Application by Fenwick Solar Farm Ltd for an Order Granting Development Consent for Fenwick Solar Farm Project

The Examining Authority's first written questions and requests for information (ExQ1)

Issued on Friday 9 May 2025

**FIGURE NUMBER**  
Figure 8-5-1

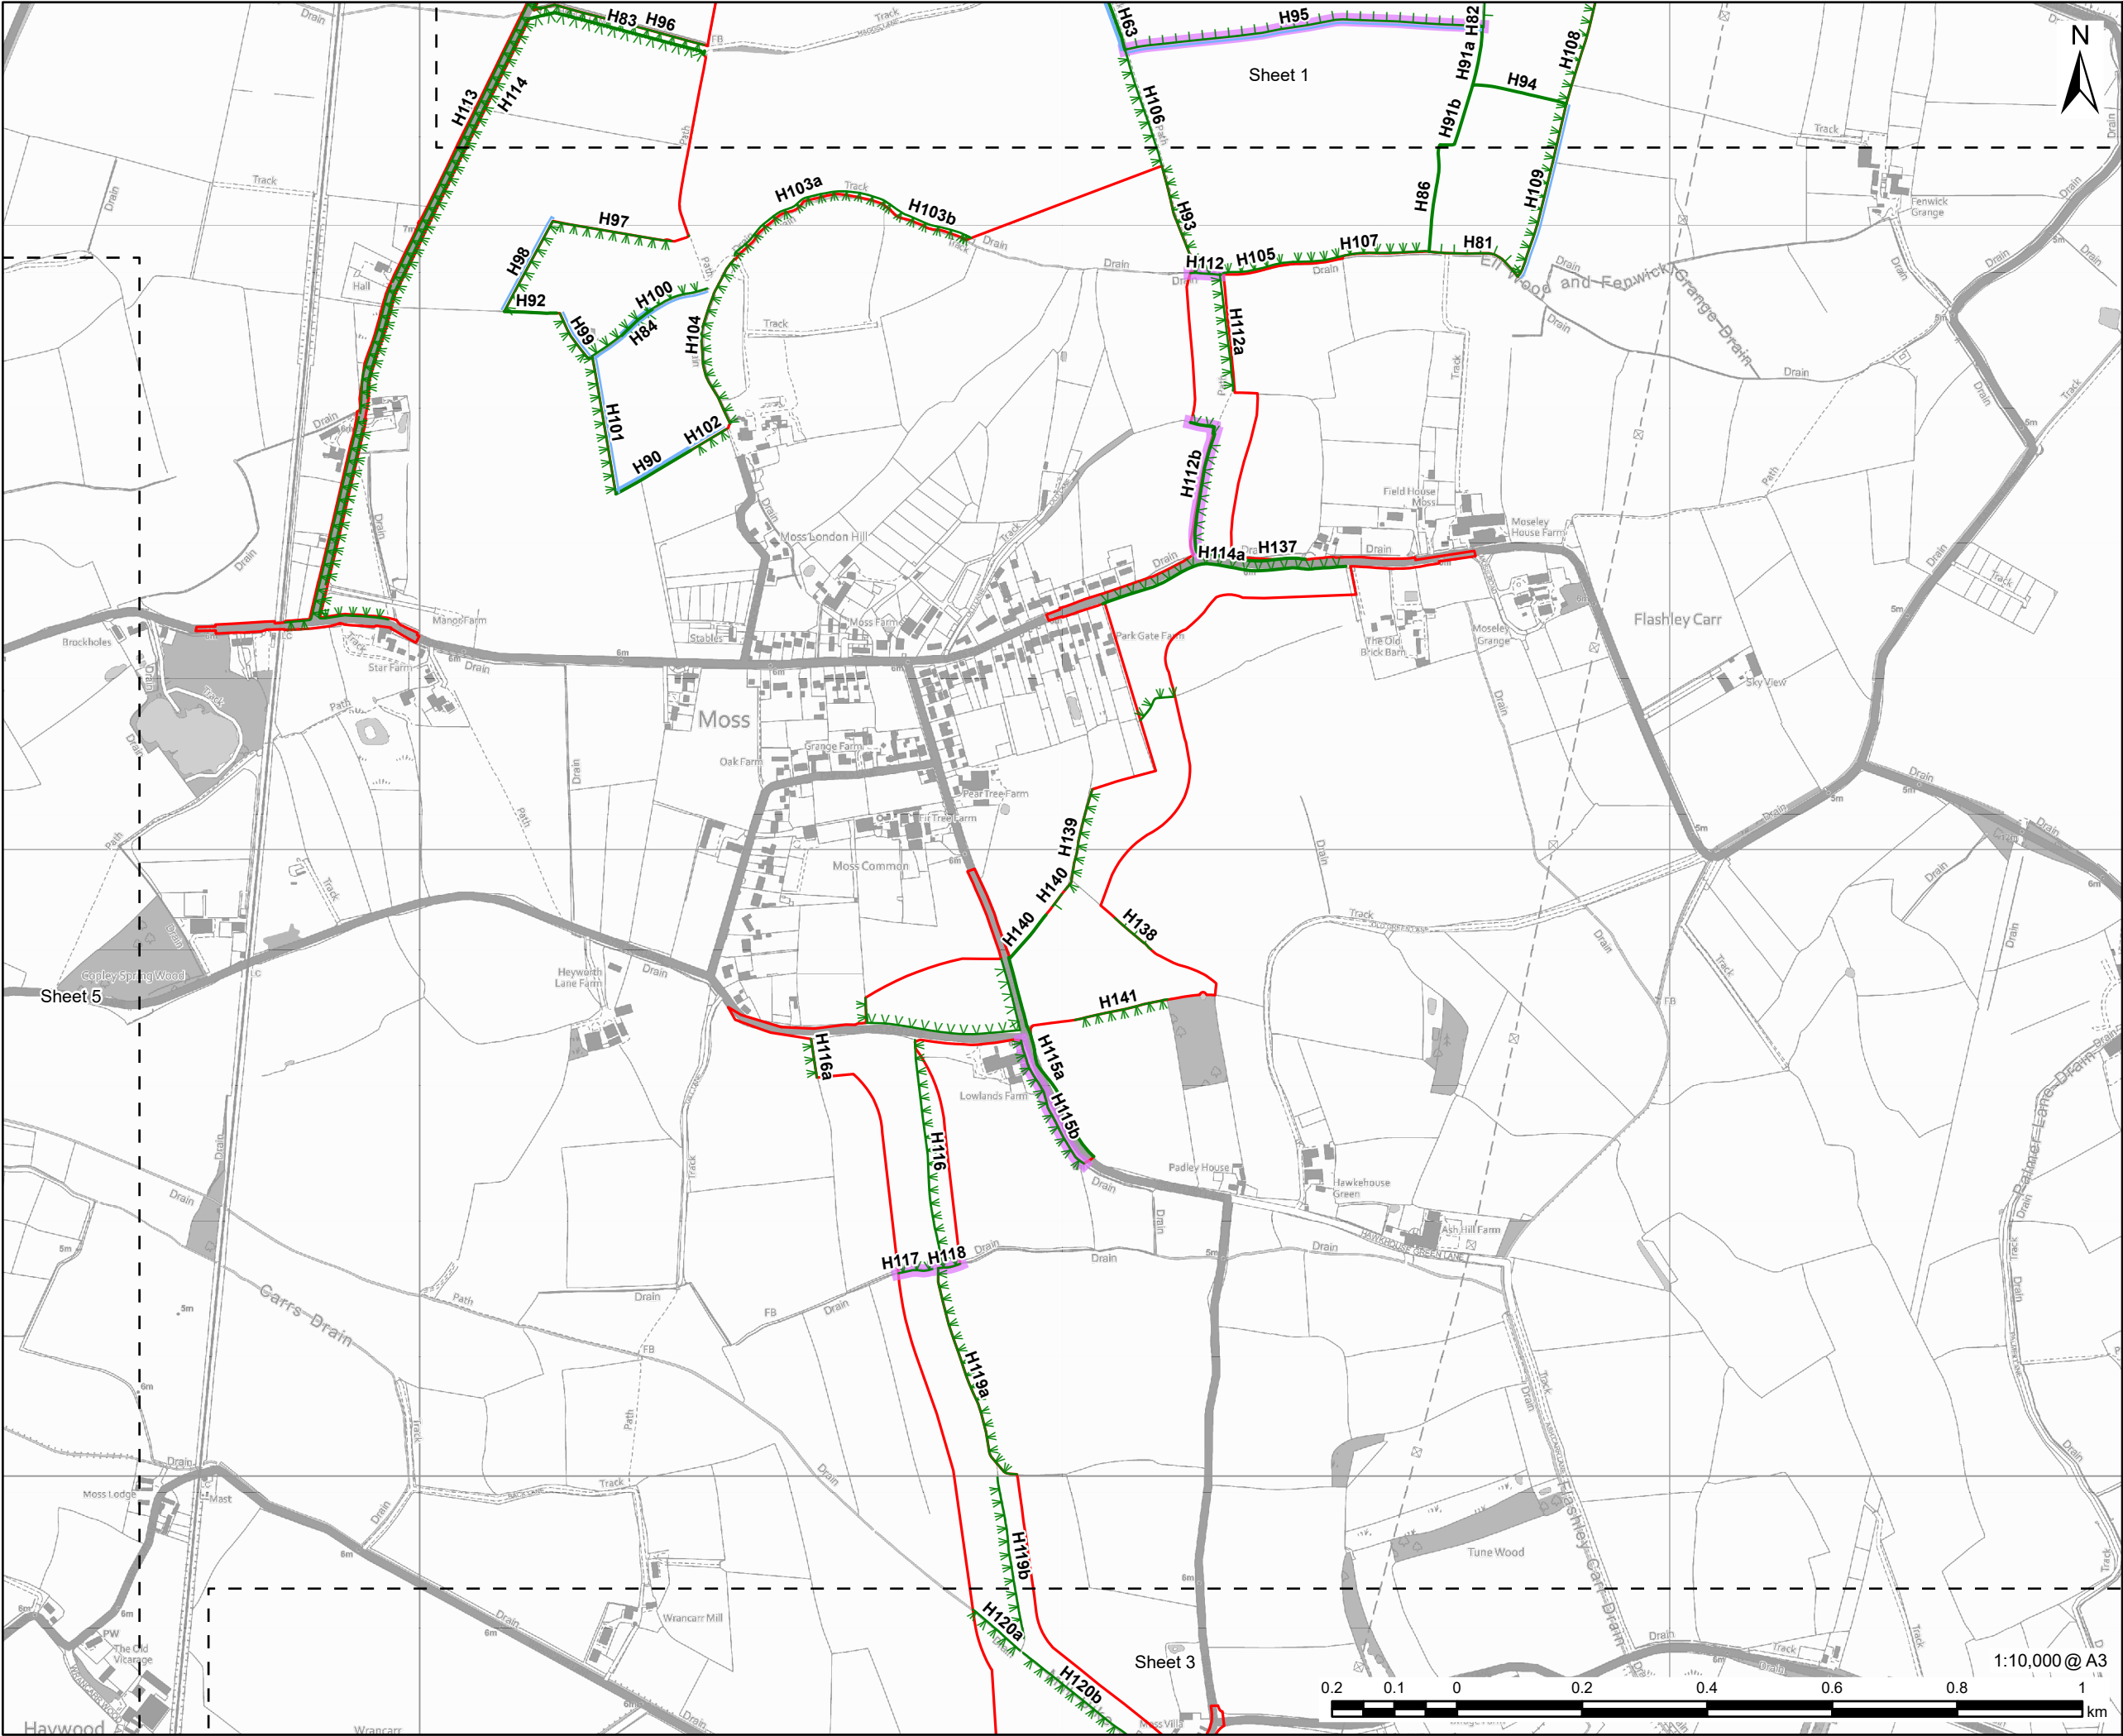
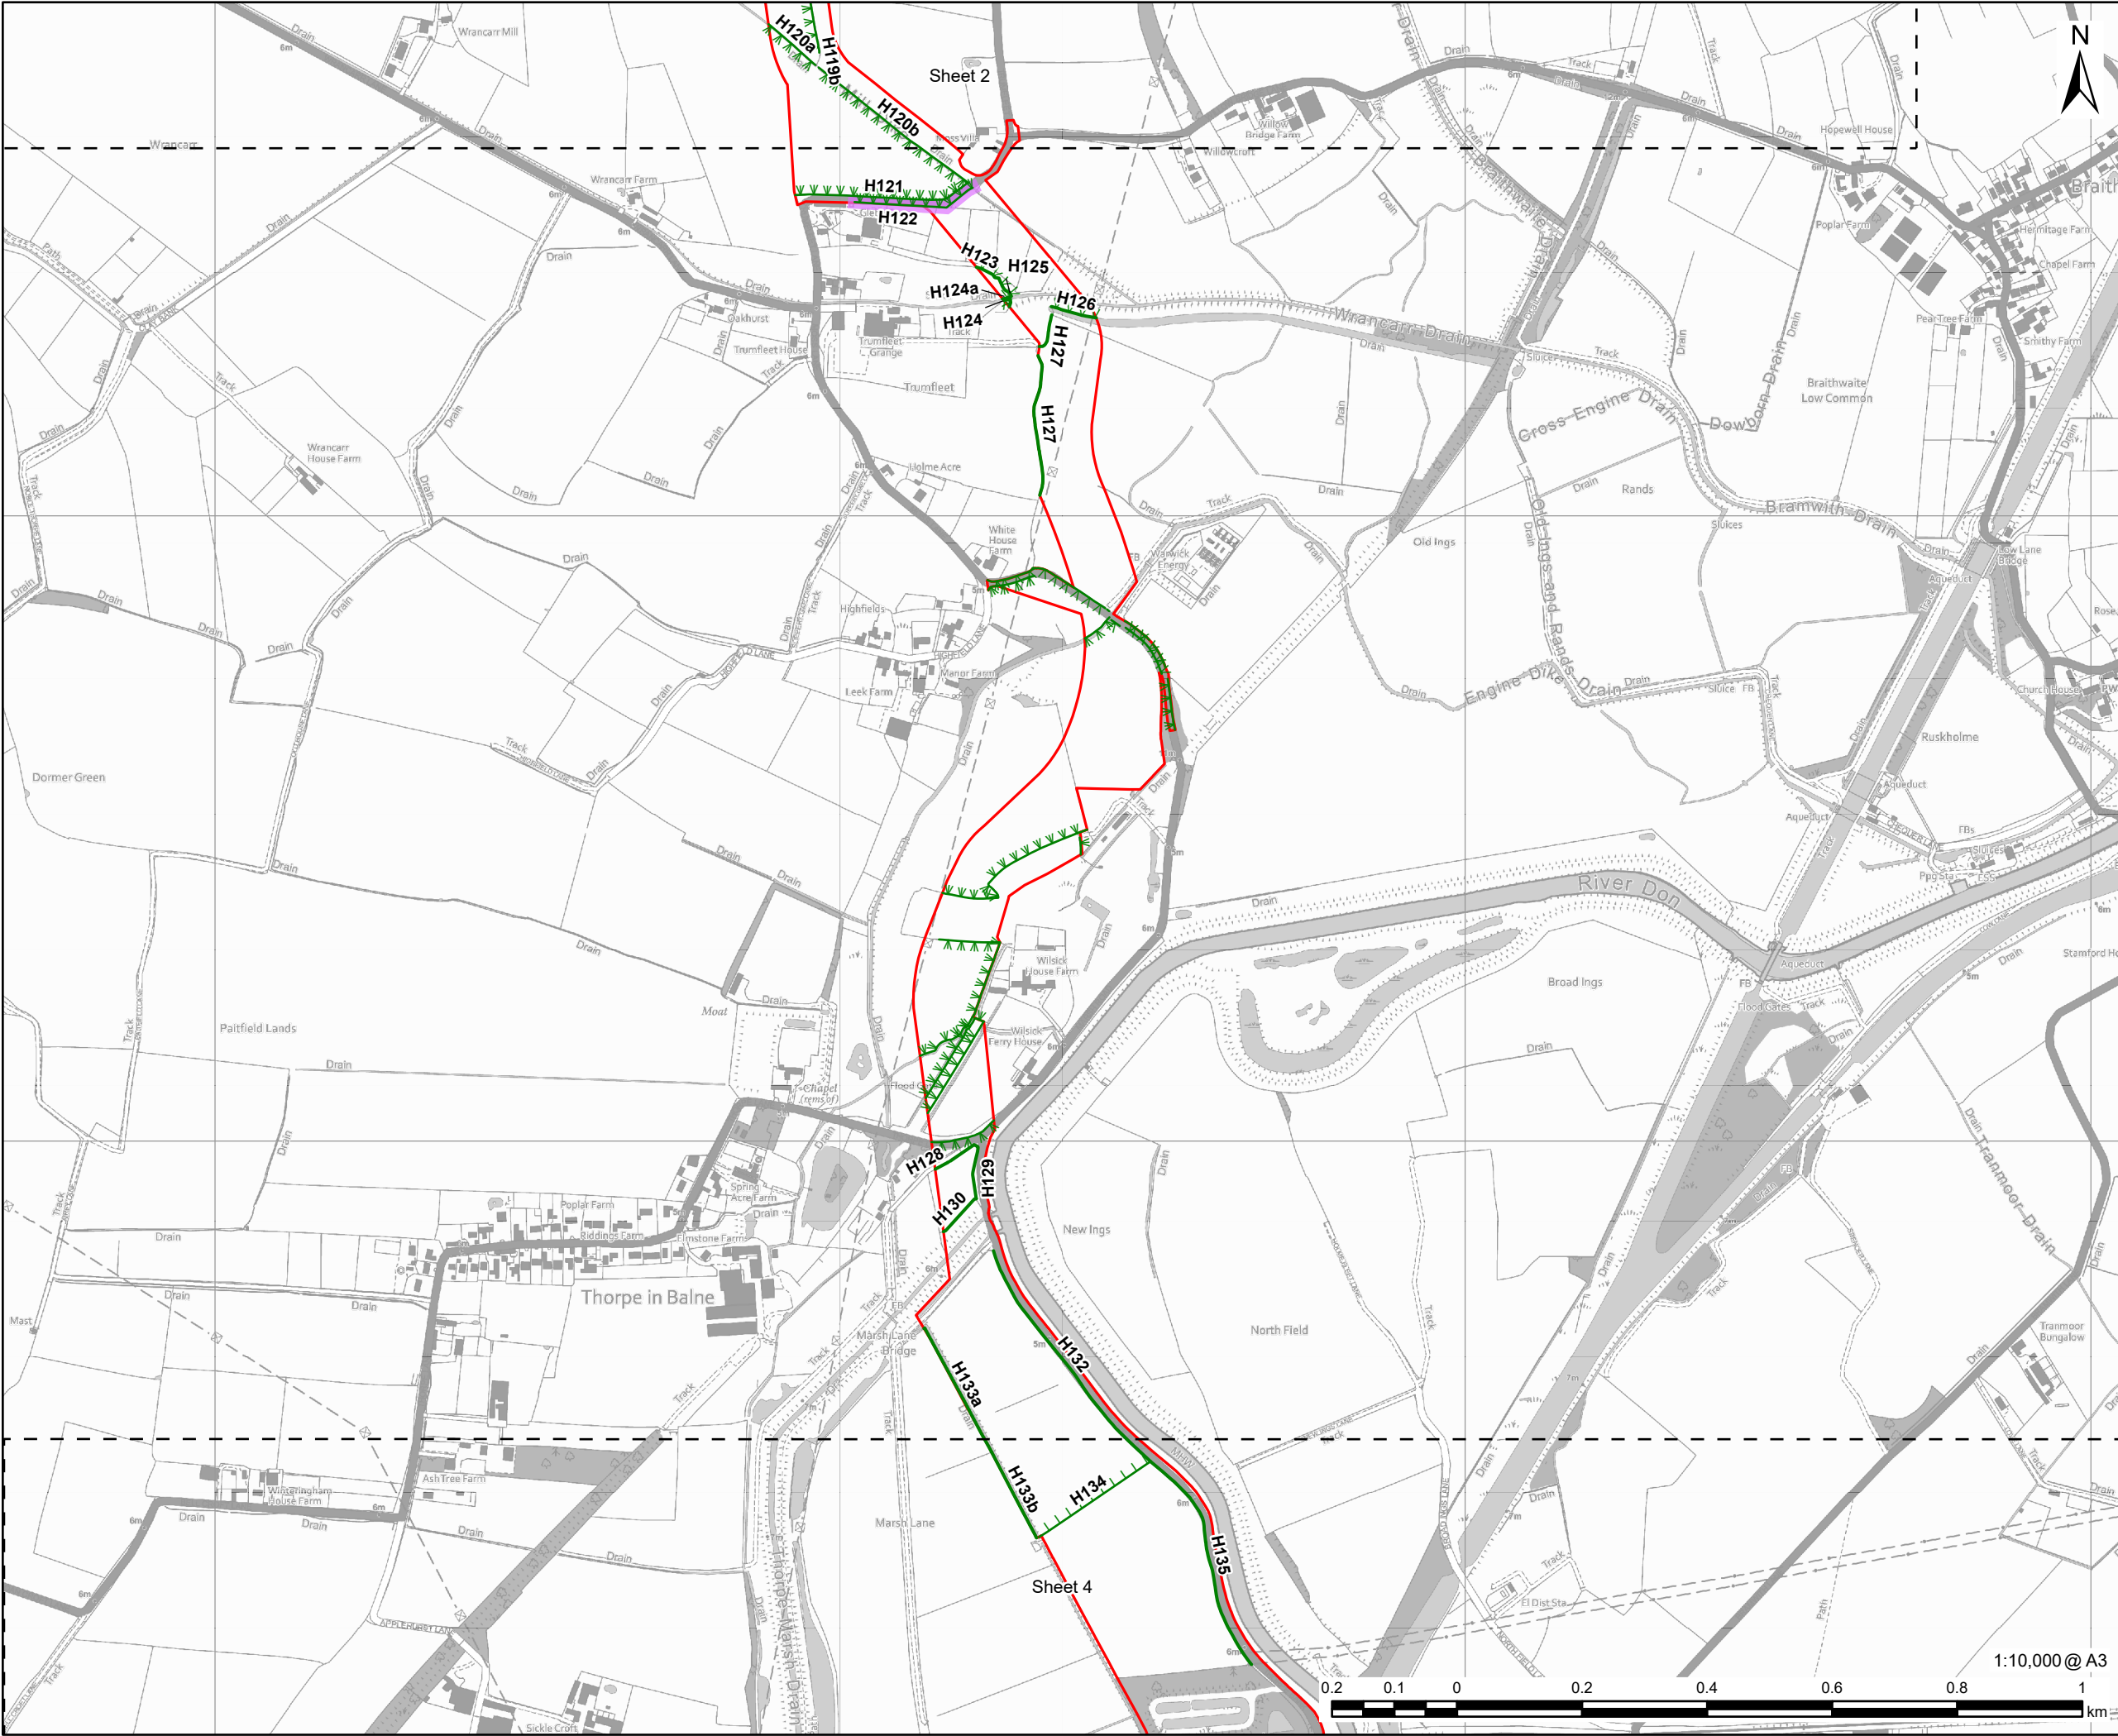
1.6.11	Applicant	Hedgerow Report [APP-150] Figure 8-5-1. Hedgerow H83 and H96 run alongside footpath Fenwick 16 (Haggs Lane). Haggs Lane is identified as the inbound access route for construction workers. Please signpost where within this report or the ES protection measures are proposed for these hedgerows during the construction phase given the need to accommodate both traffic and rights of way users along Fenwick 16.
